URBAN DESIGN and LANDSCAPE COMMENTS

Site Address: **HOLLAND AND HOLLAND SHOOTING SCHOOL, DUCKS HILL ROAD**

Planning ref: **16568/APP/2026/703**

Proposal: Demolition of existing site buildings (excluding the retained central timber-framed barn), removal of existing hardstanding including the menage, change of use of part of the land to a workshop use (Use Class E(g)(iii)), and redevelopment of previously developed land to provide a workshop building with associated parking, hard and soft landscaping, formation of a pond, regrading of land levels, improvements to the existing access, sustainable drainage measures, and on-site biodiversity net gain enhancements.

Site Strategy : General Principles of massing and the interrelationship of the proposed building and landscape

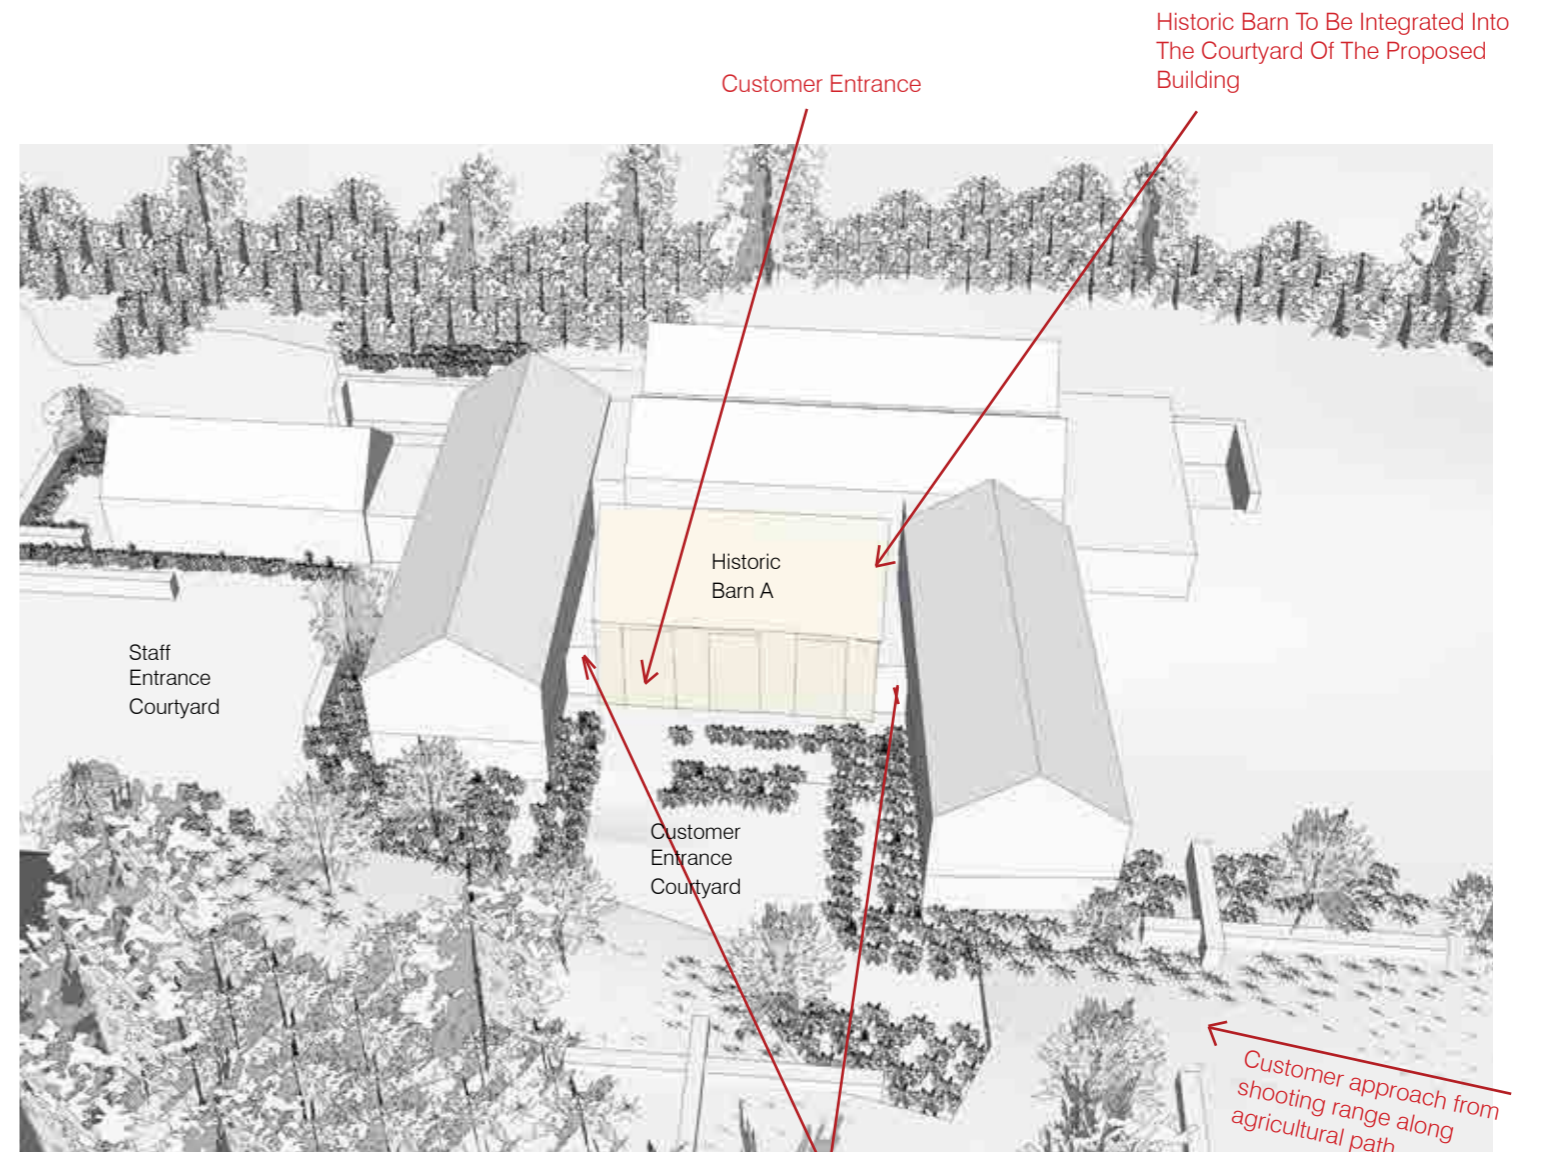
The proposed buildings are broadly uniform in height and, in some cases, marginally larger in scale than the existing heritage barn proposed to be retained.

While the building heights proposed are slightly higher than the existing heritage structure, the applicant has proactively engaged with the Council to reduce excavation across the site to reduce the level changes around the buildings and retain the edge planting. This approach is supported. This approach avoids such significant ground disturbance and associated level issues. Furthermore, the Landscape and Visual Impact Assessment (LVIA), including existing and proposed views, demonstrates that the resulting visual impact on the Green Belt is very marginal.
